Response to Planning application from Hertfordshire County Council (T and CP GDP Order 2015)

District ref: 6/2023/1124/FULL
HCC ref: WH/17057/2023
HCC received: 28 September 2023
Area manager: Manjinder Sehmi
Case officer: Senober Khan

2 Hill Rise Cuffley Potters Bar EN6 4EE

Erection of 5 bedroom dwelling following the demolition of existing dwelling

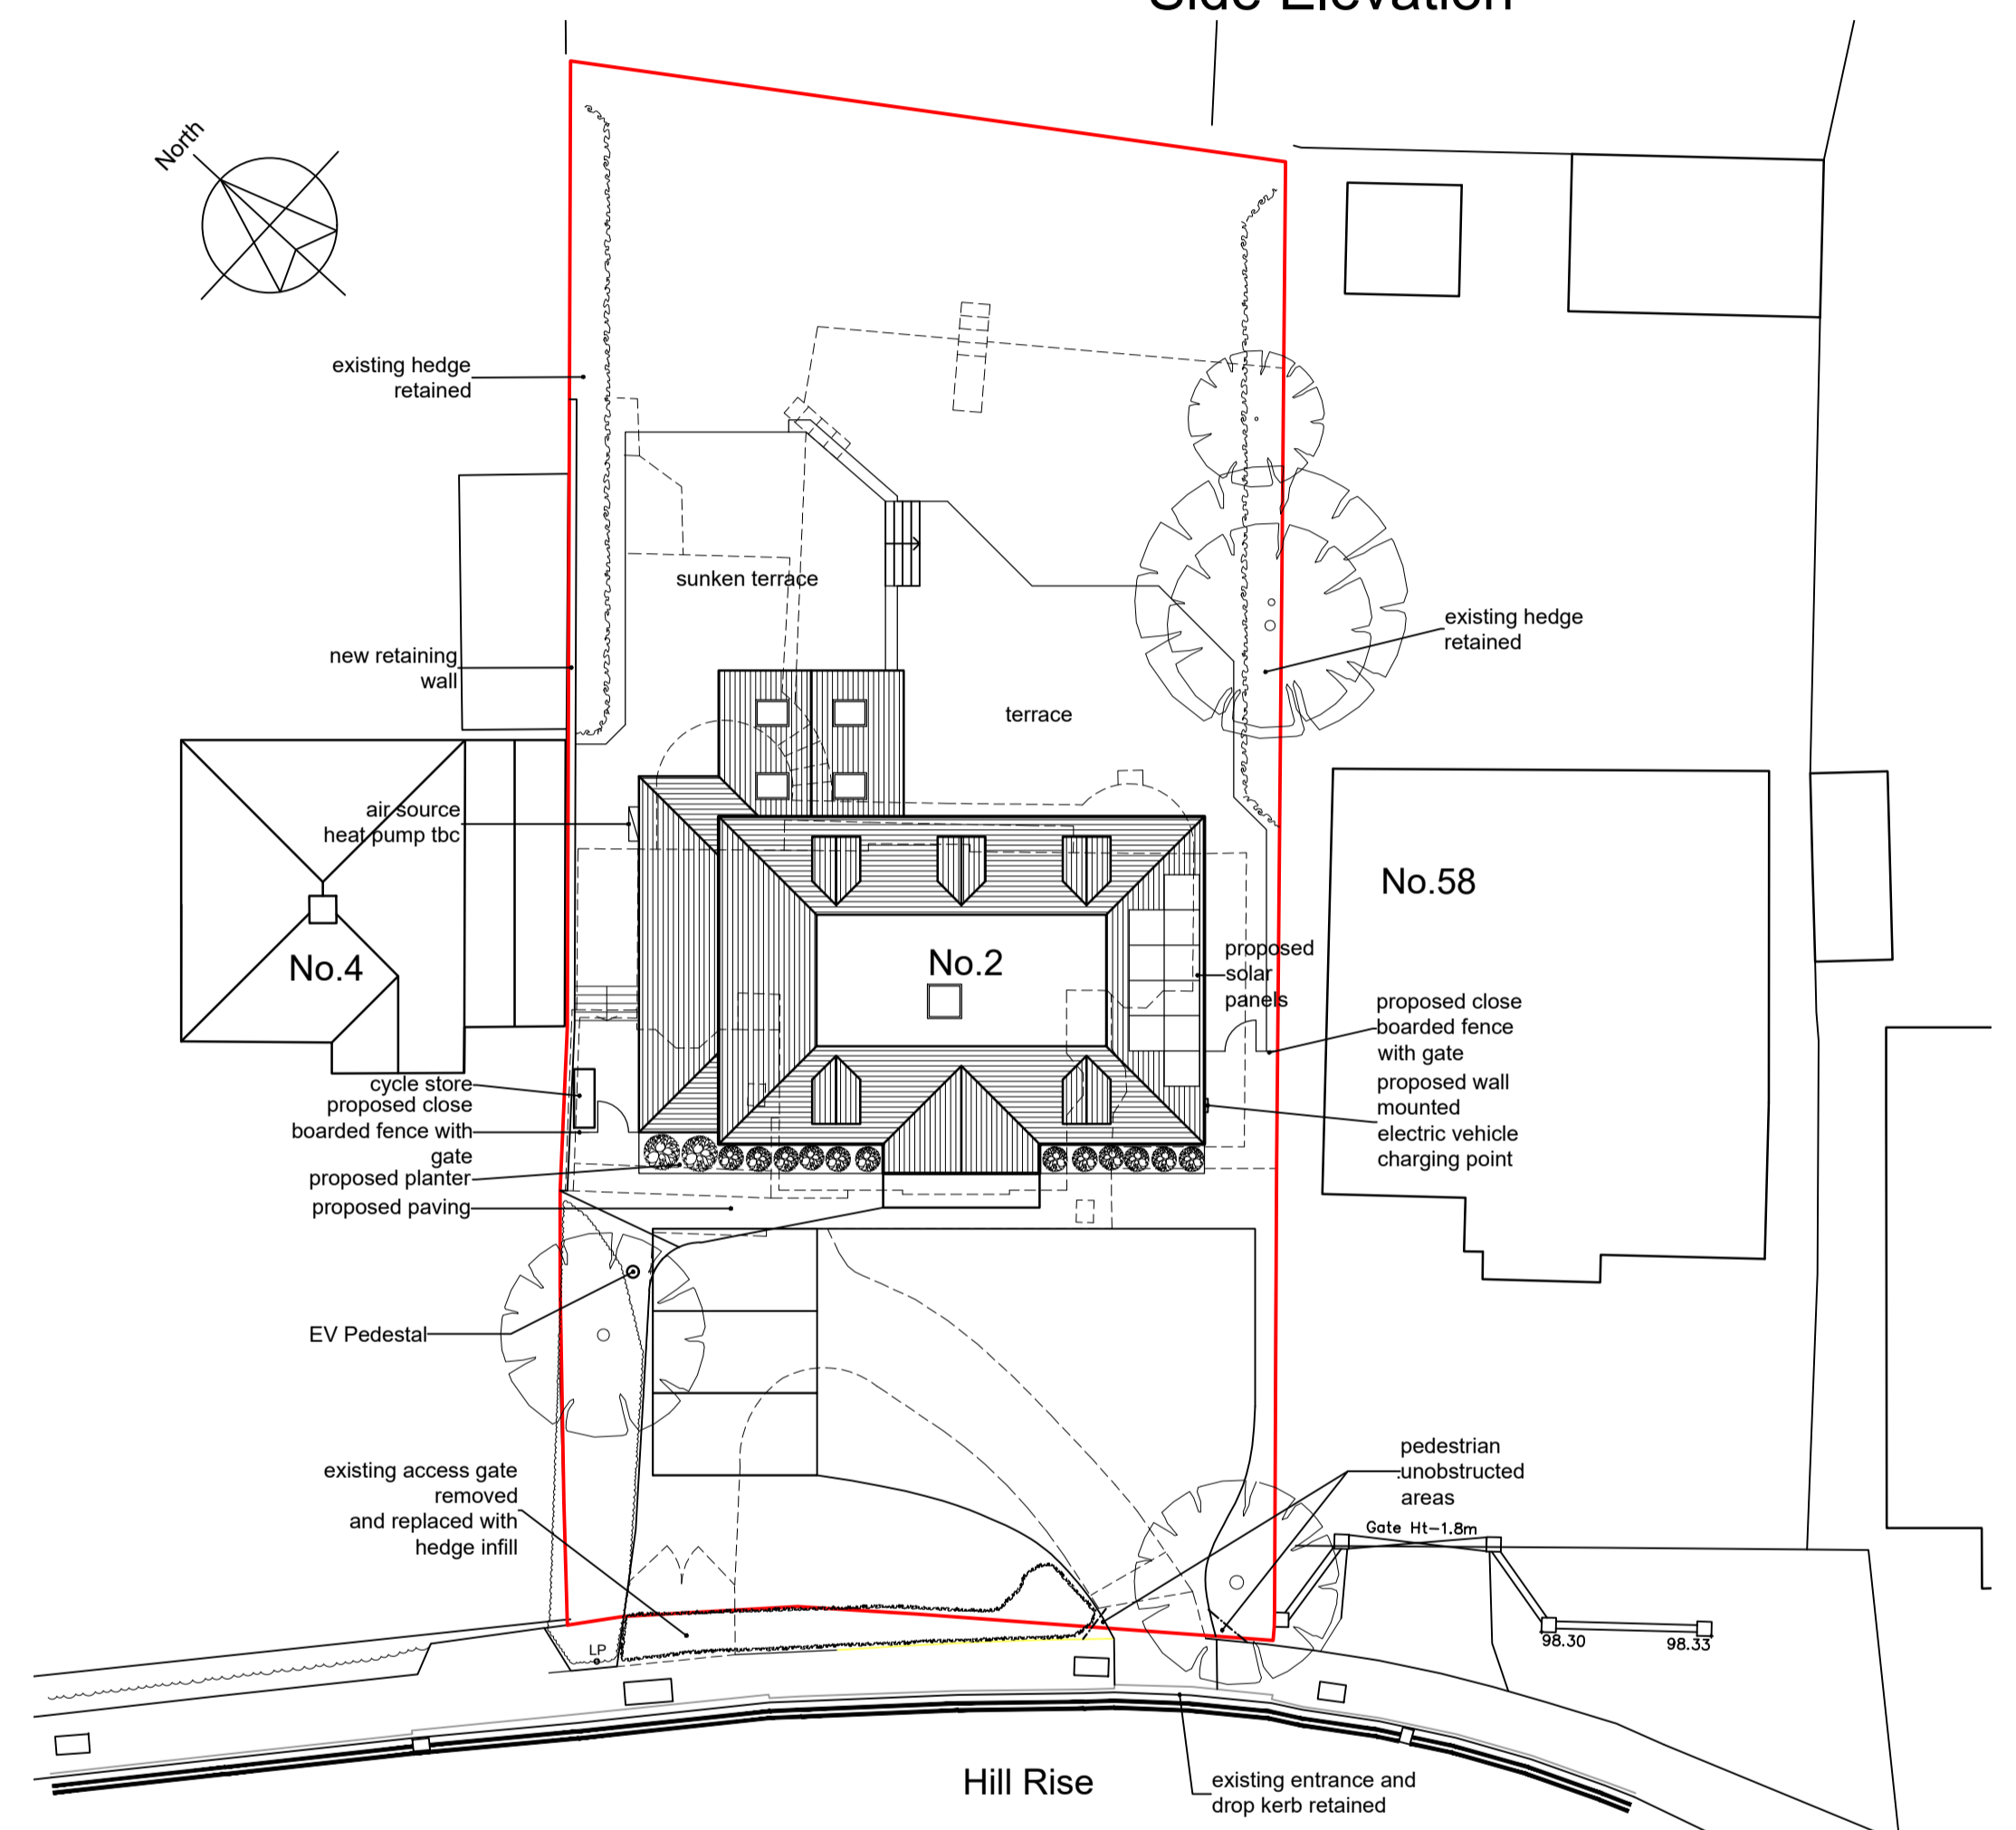
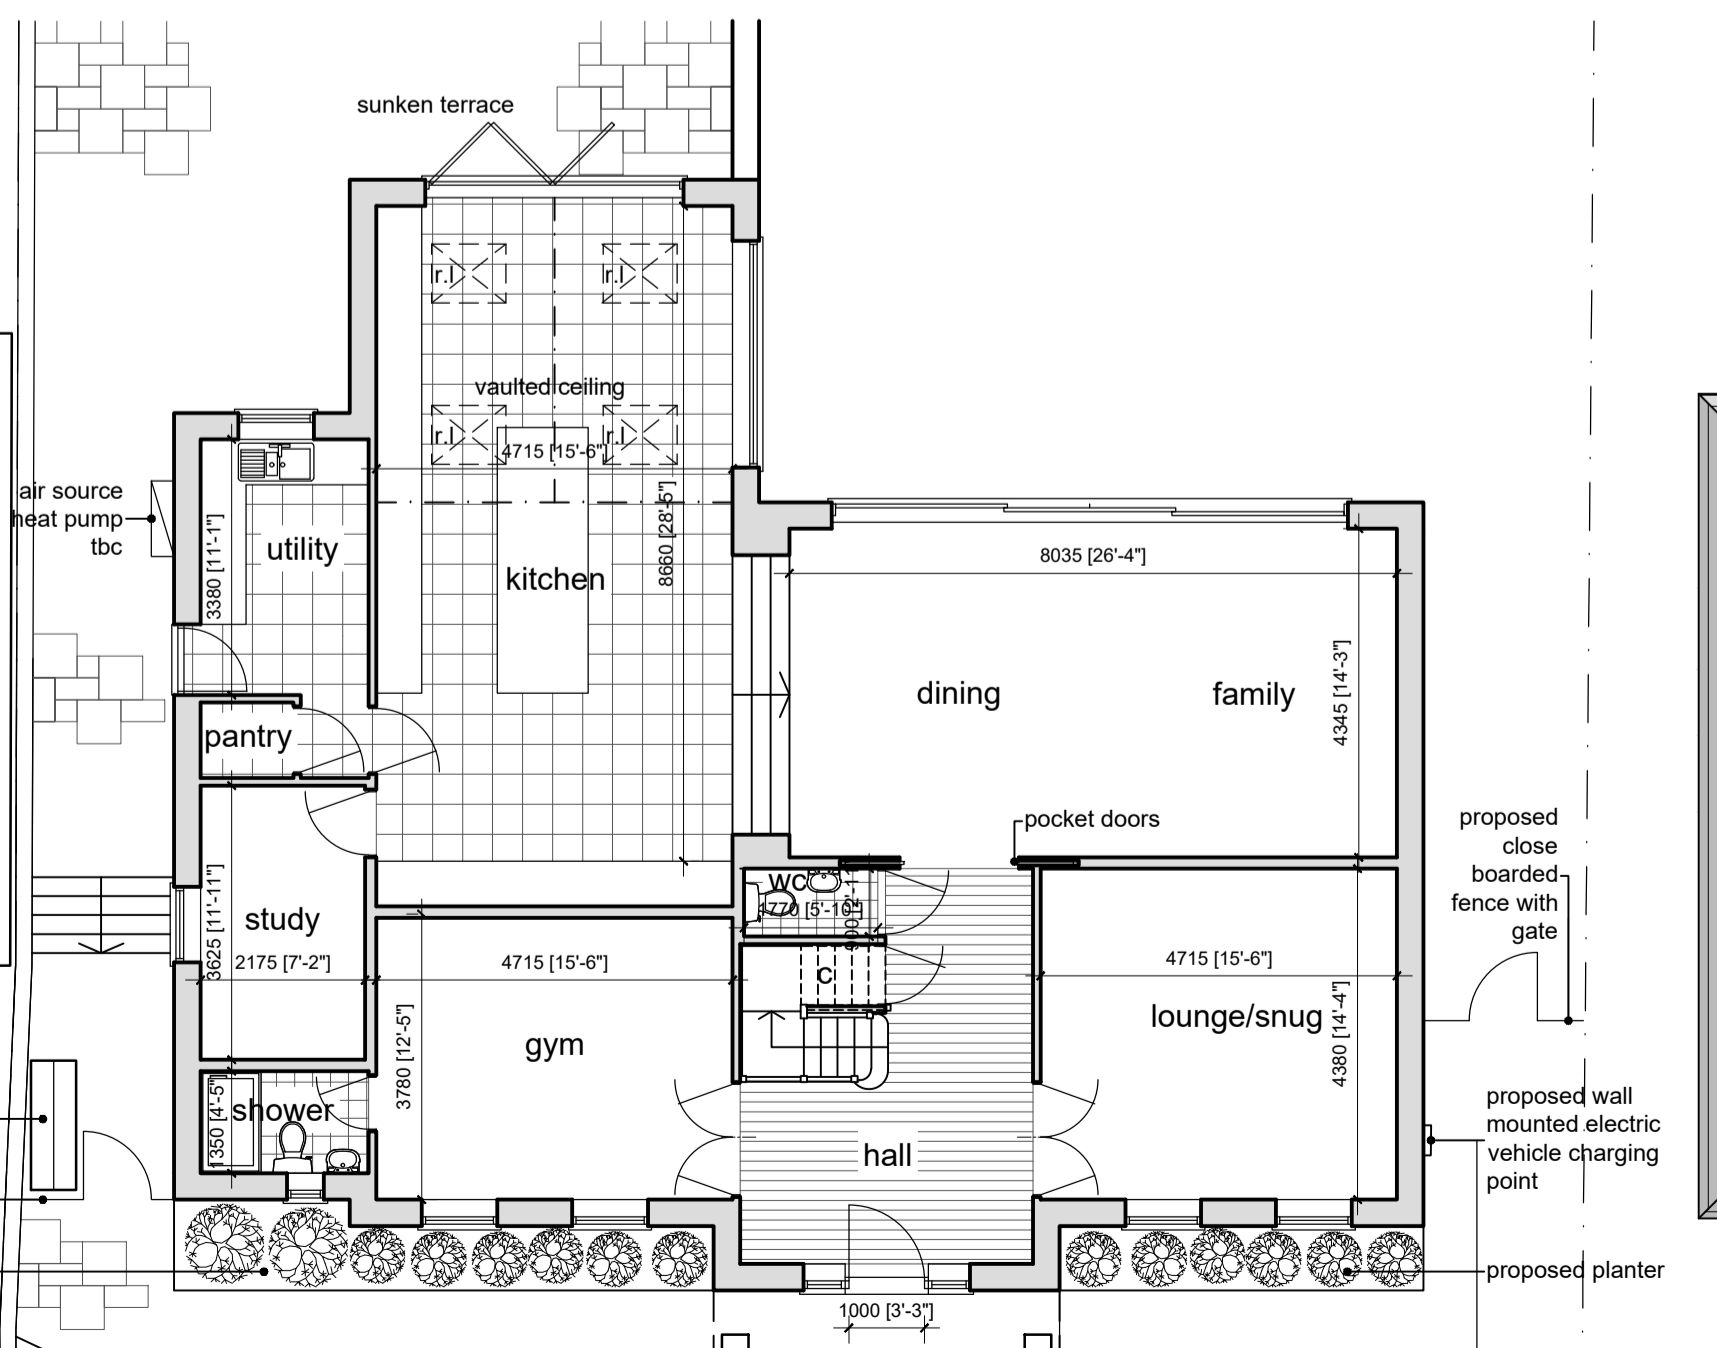
The existing redundant northern dropped kerb should be returned back to footway and to be completed prior to occupation of the development hereby approved.

In response to the HA's comments and to address the HA concerns, the applicant's consultant has submitted amended drawings 20536-P001-D & 20536-P002-C, indicating amendments to the access arrangements by closing off the existing northern vehicle access with gate removed and replaced with hedge, and existing southern entrance retained with pedestrian visibility splays shown, providing one access point onto the site only.

The HA has reviewed the amended drawings and is satisfied that the revised proposals as indicated in the amended drawings 20536-P001-D & 20536-P002-C now satisfactorily address the HA's previous comments and the proposed development is now acceptable.

The vehicle access with pedestrian visibility splays shall be constructed and laid out in accordance with the agreed details and completed prior to occupation of the development hereby approved and shall thereafter be retained and maintained at all times.
